Application No: BN/16/22/PL
Site Address: Land to the rear of Clare Court 67 Barnham Road Eastergate PO22 0EP
Description of works: Erection of 4 No dwellings with associated car parking. This application is in CIL Zone 2 and is CIL Liable as new dwellings.

Thank you for your internet representation made on 7th March 2022 which has been recorded as an objection with the comments as follows:

PROPOSED SITE PLAN . Scale 1:250 at A3

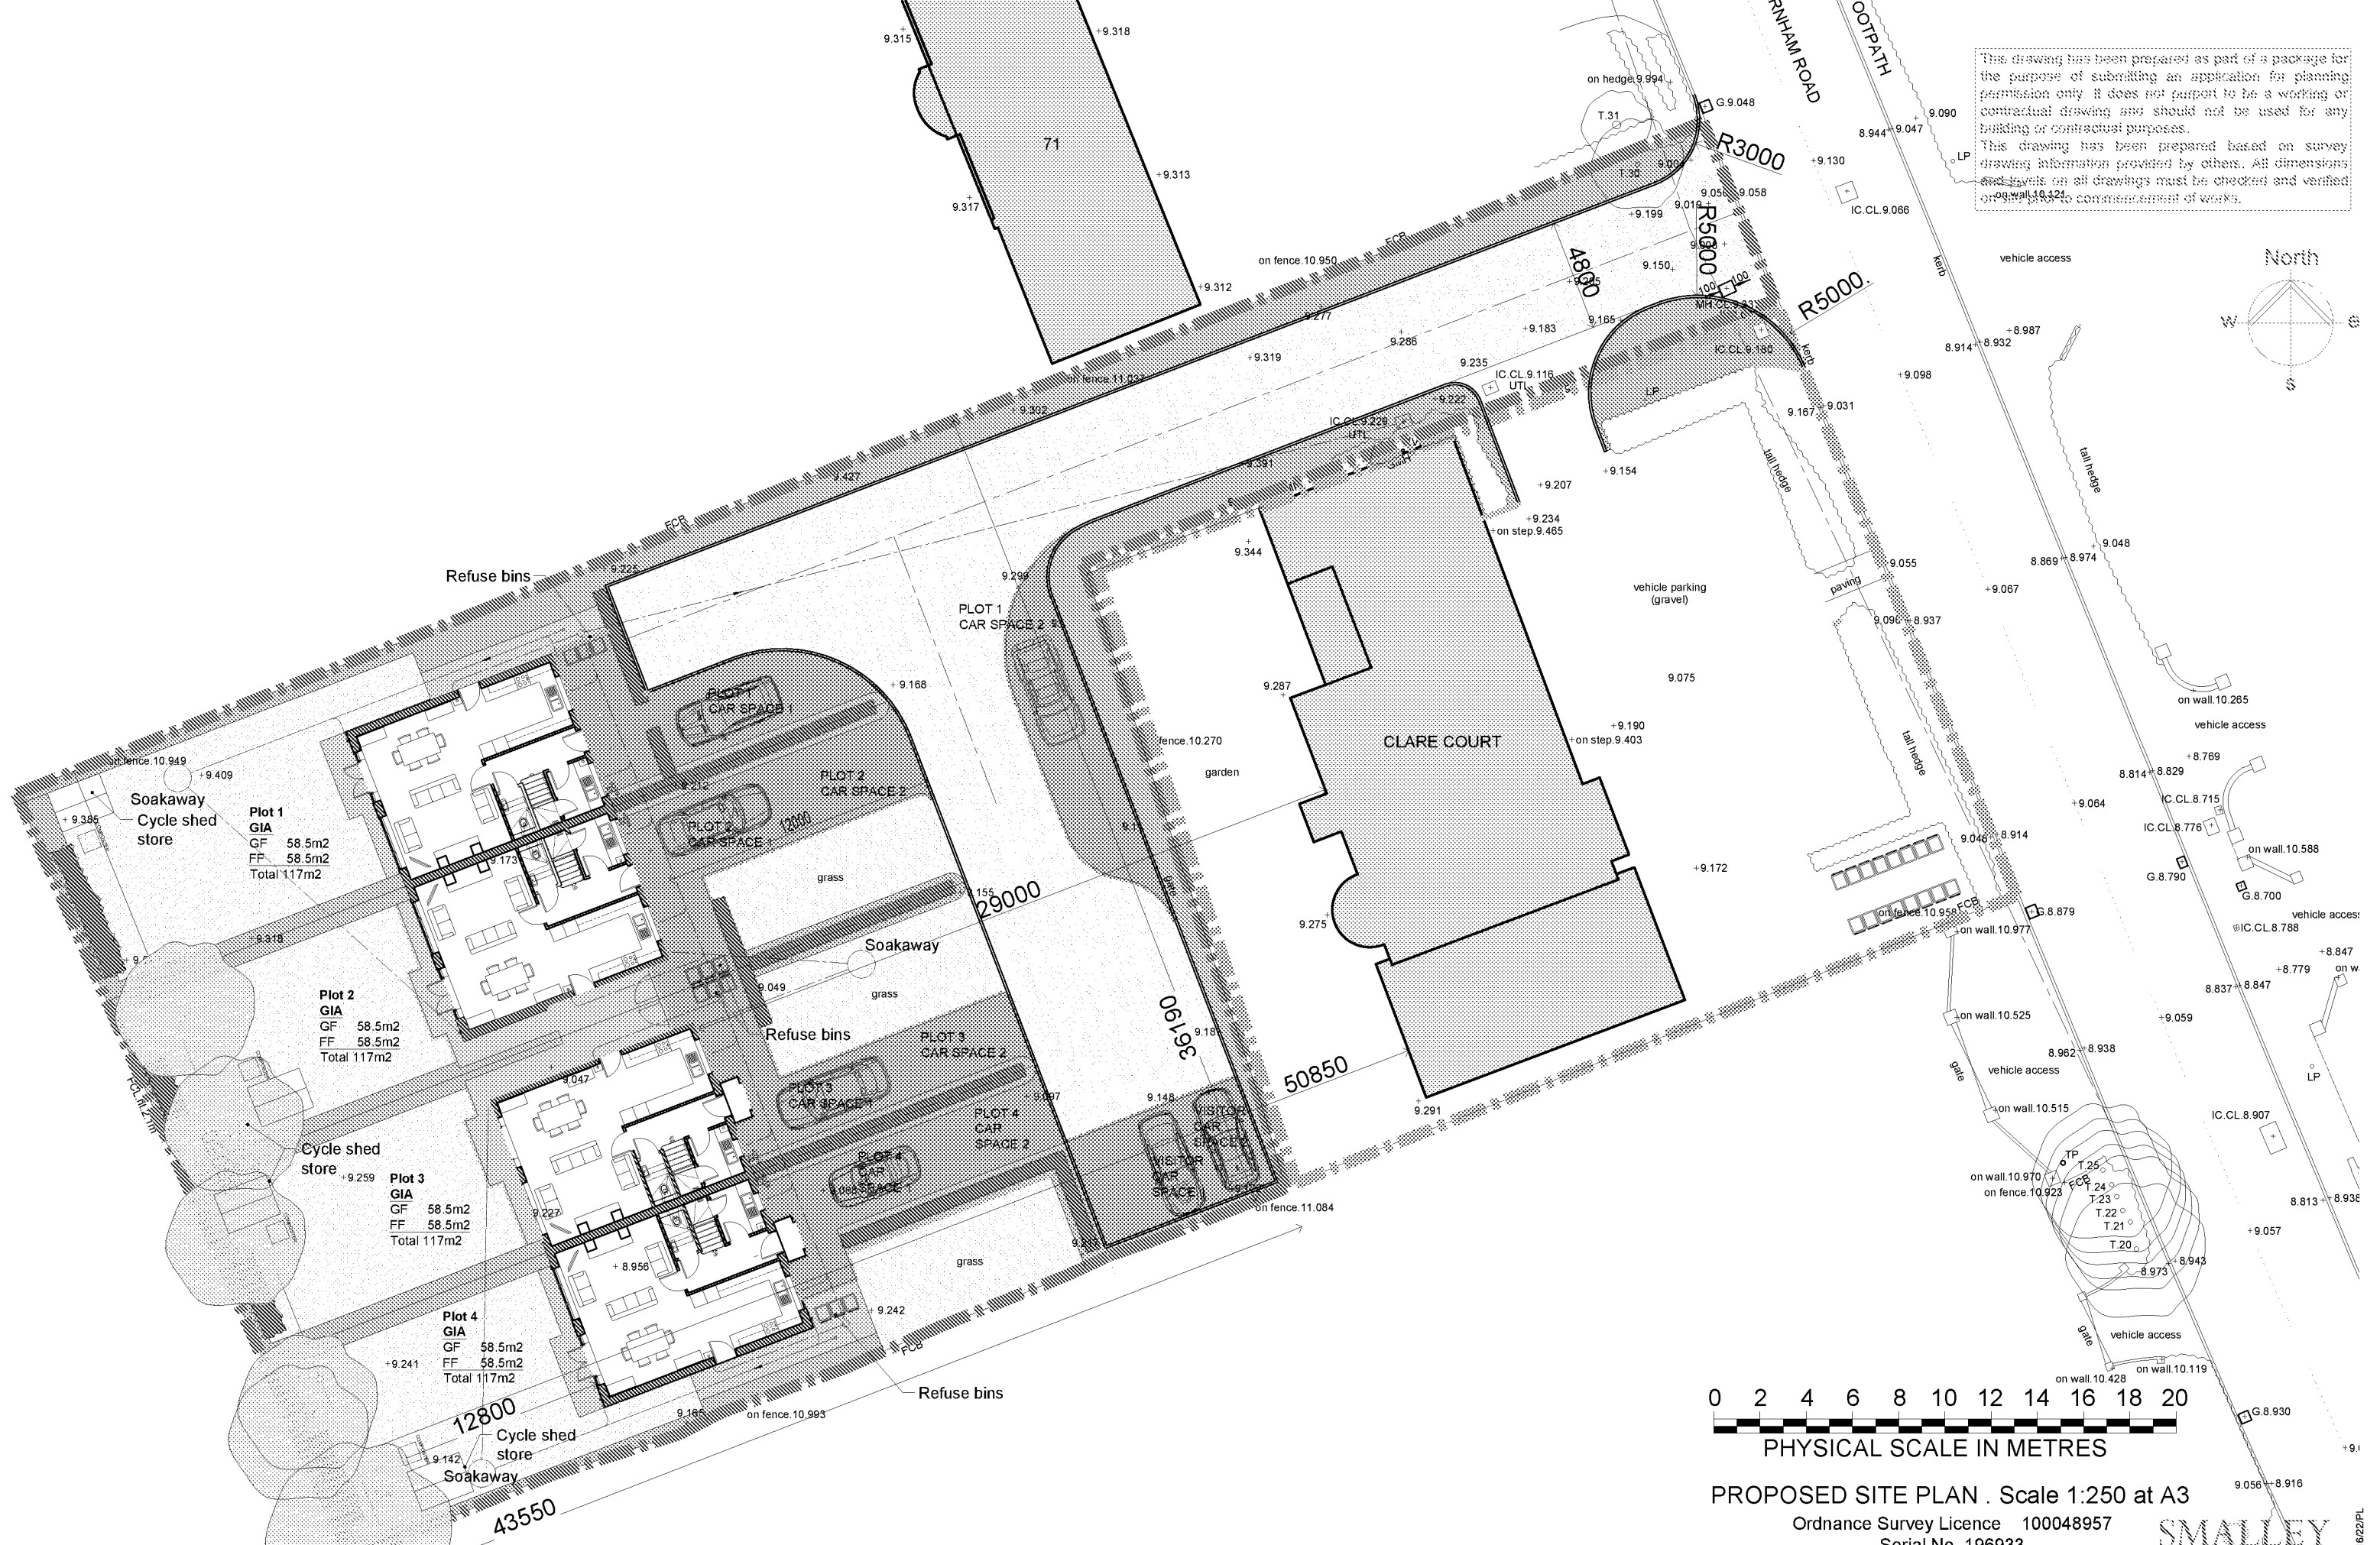
- 3) Highways - The proposed access from the Barnham Road (B2233) is inadequate due to poor sight lines.
- 4) In the last few years, a large number of mature trees were felled and now the applicant is representing that there are no trees of value. This is disingenuous and implies that the applicant is playing the system. If ADC are minded to approve this application a condition should be included to ensure that mature trees are planted to act as a visual screen between this development and the neighbouring properties.

4 NO. 3 BED DWELLINGS
PROPOSED STREET SCENE AT

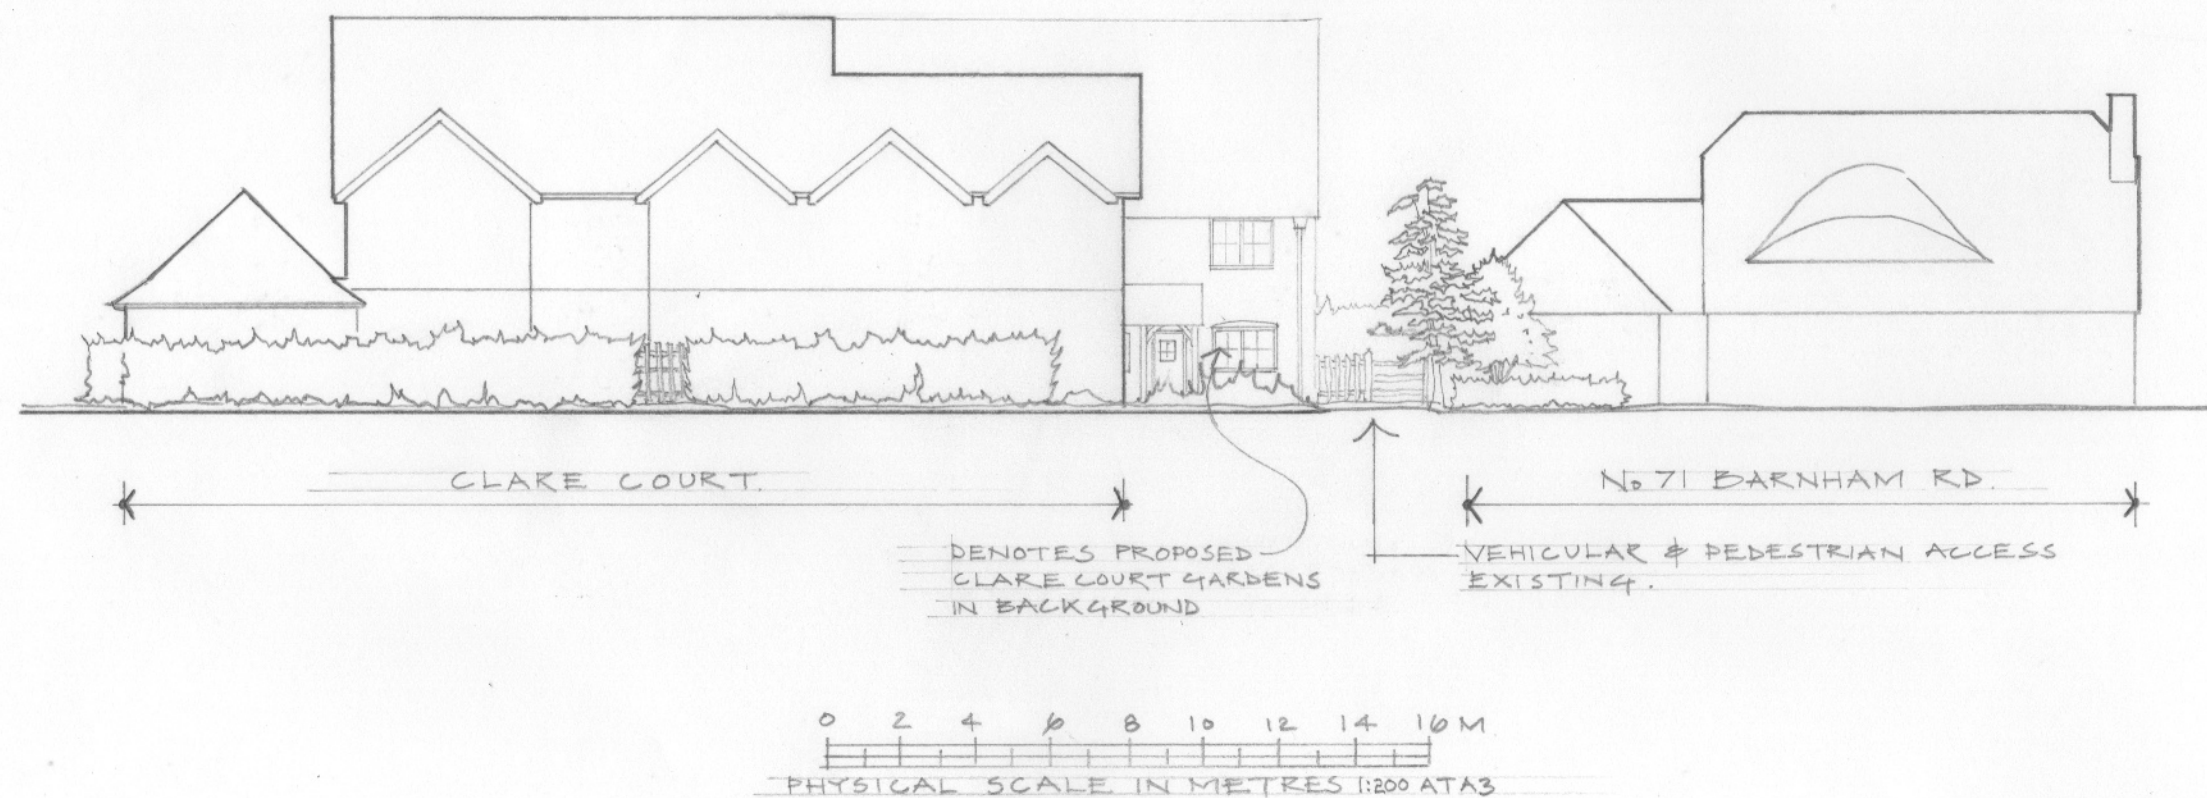
- 1) Designated Area of Character - Local Plan 13.2.9: The site sits within a Local Plan designated Area of Character. The proposed development is not in keeping with the character of the area. The height and massing of the four houses interrupts and debases the rhythm of the existing building and roofing line especially when viewed from the rear gardens of neighbouring properties.
